MEMORANDUM

TO: Bill Needelman, Planner
FROM: David Senus, P.E. & Ashley Auger, E.I.T.
DATE: December 14, 2012
RE: 40 West Commercial Street, Final Level III Site Plan Application

Woodard & Curran has reviewed the Response to Comments on the Final Level III Site Plan Application for Phase I of the Canal Landing Development at 40 West Commercial Street in Portland, Maine. The project proposes to construct a boat repair and maintenance yard along with related marine uses over the course of multiple phases. Phase I will include construction of a tension fabric building and associated utilities, concrete boat ramps along the shorefront, establishment of yard areas, and marine improvements.

DESIGNED BY: CMW  
 CHECKED BY: SRB  
 FILE NAME: 3091.02-GRADING  
 SHEET: C-3.1

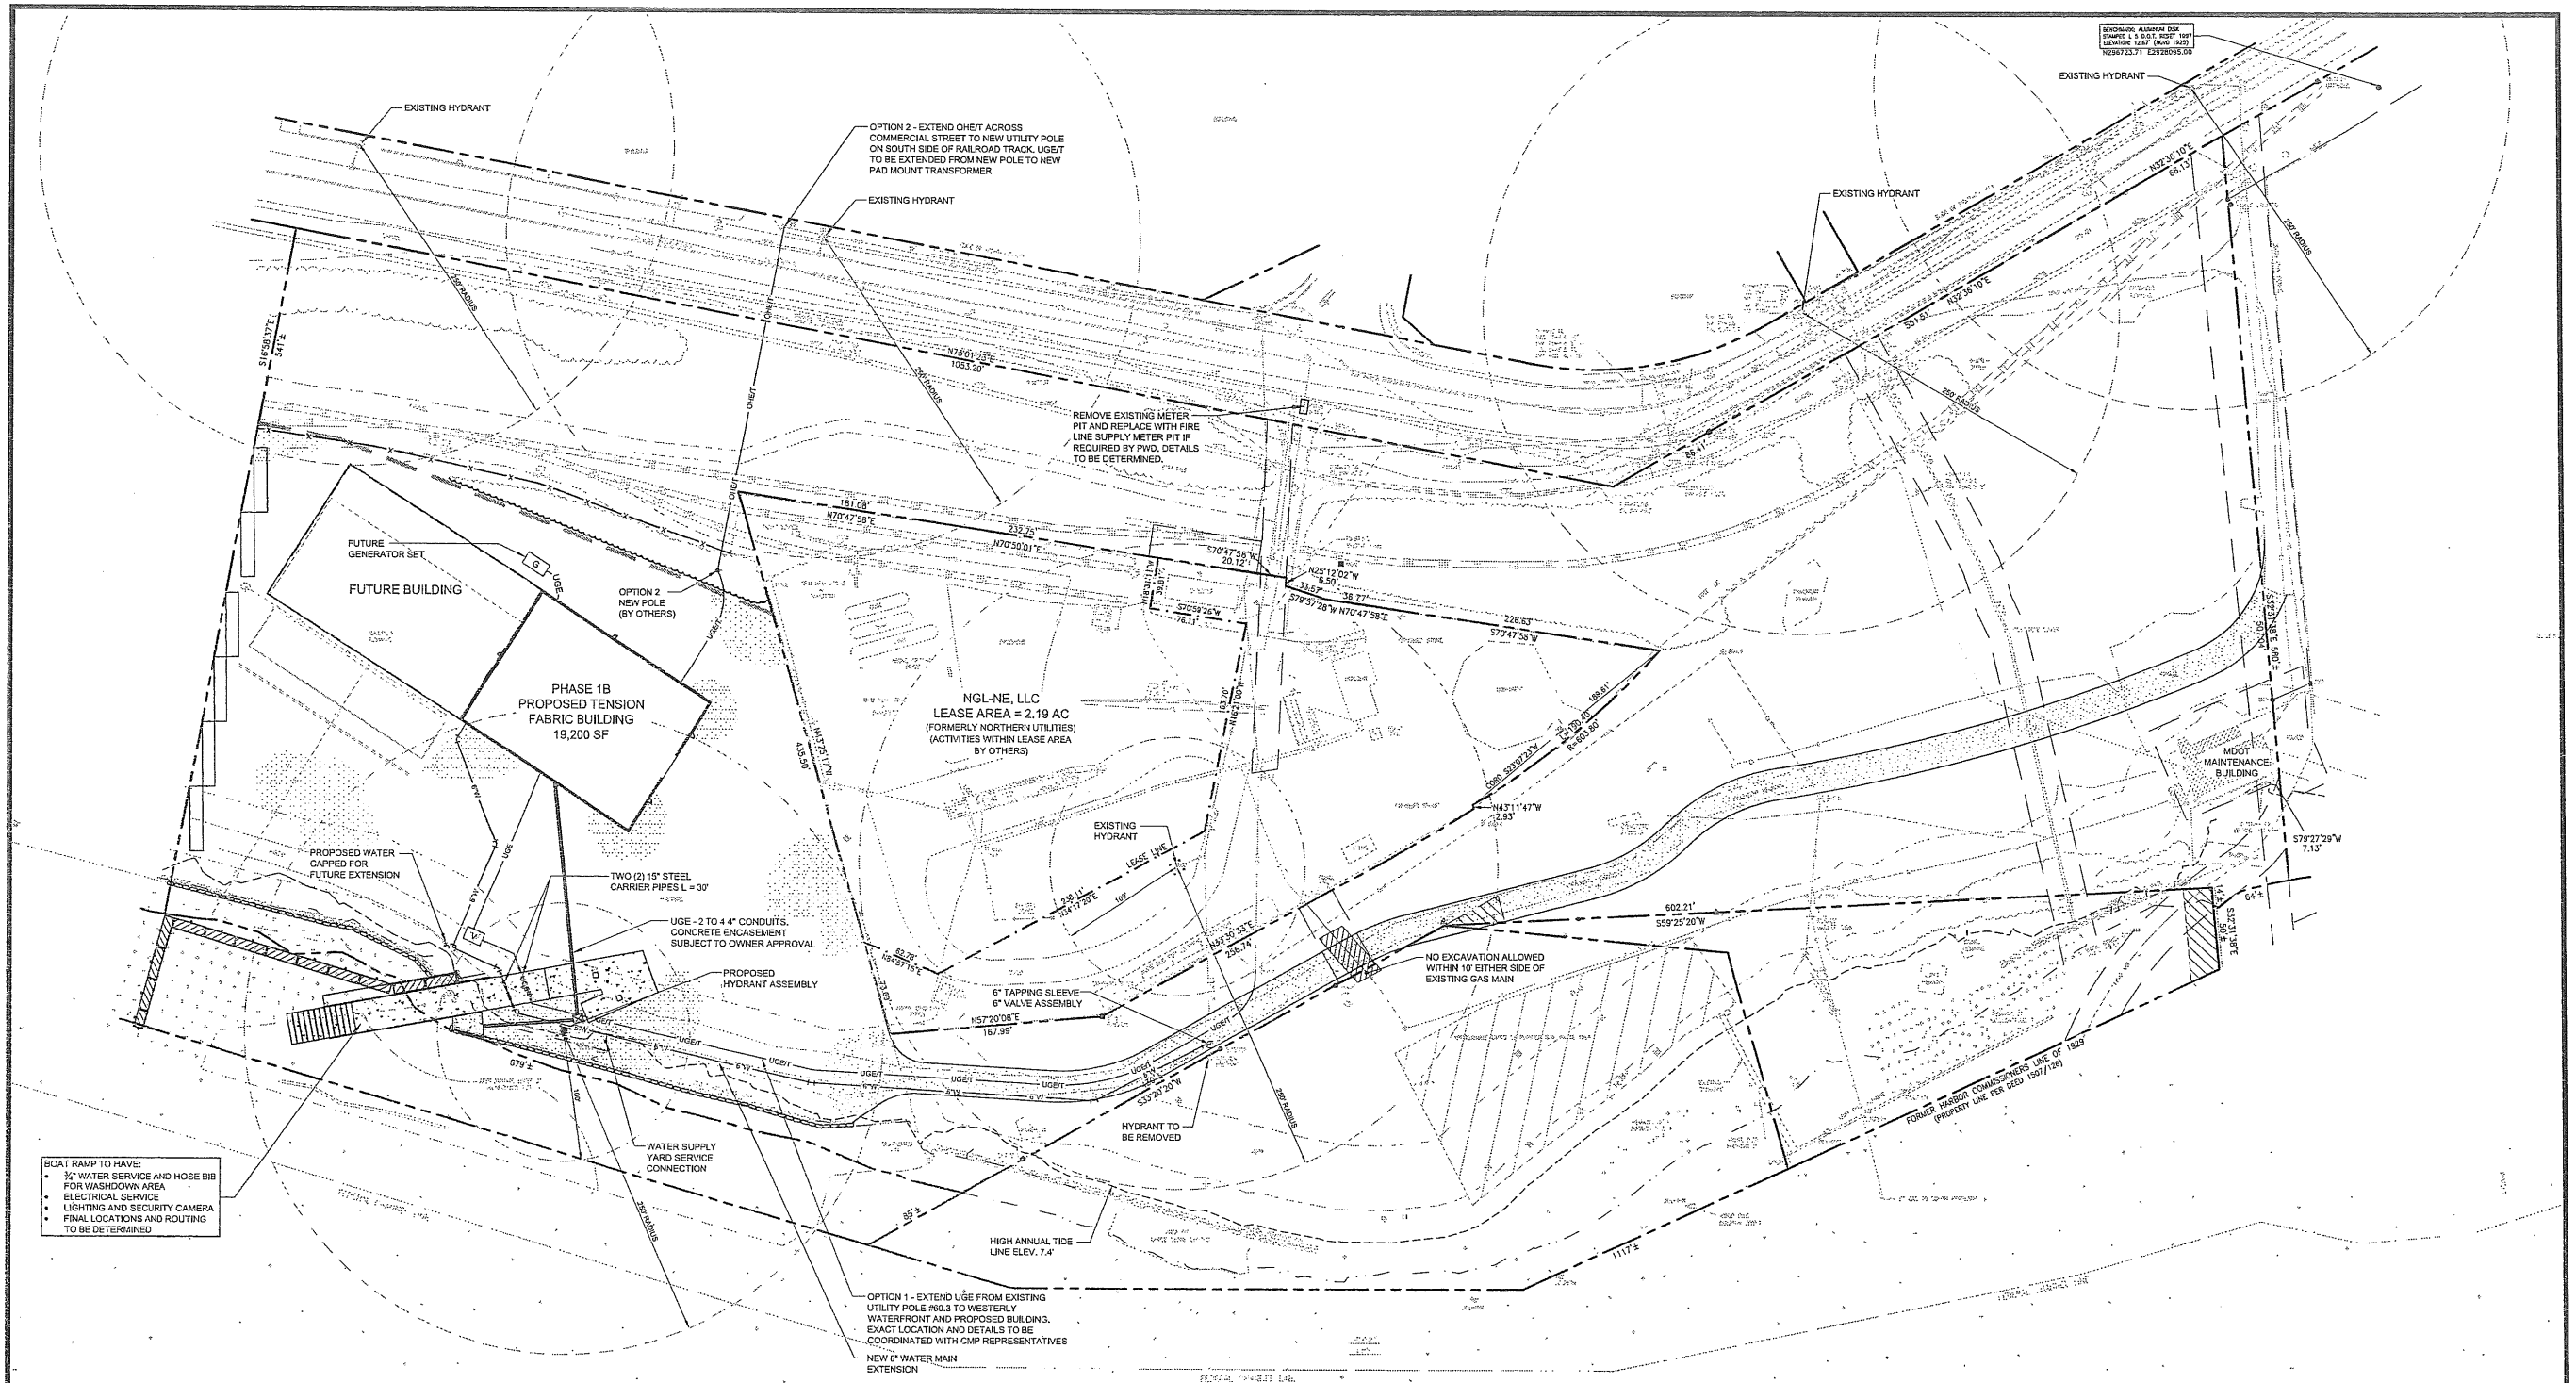
- 2) The Grading & Drainage Plan depicts "Stormwater Management Areas" along the east and south of the improved "Boatyard Surface" area. These areas are intended to collect and manage stormwater during larger storm events. We recommend adding additional "Stormwater Management Areas" to the west, south of the driveway access the Travel Lift Basin and Boat Ramp (between the "Boatyard Surface" and the seawall); so long as this is acceptable to the MaineDEP in consideration for the site's VRAP.

- 3) The Applicant has indicated that the "Stormwater Management Areas" noted on C3.1 are intended to be grassed swales, as detailed on Sheet C6.3. The plans should reference this detail for clarity.
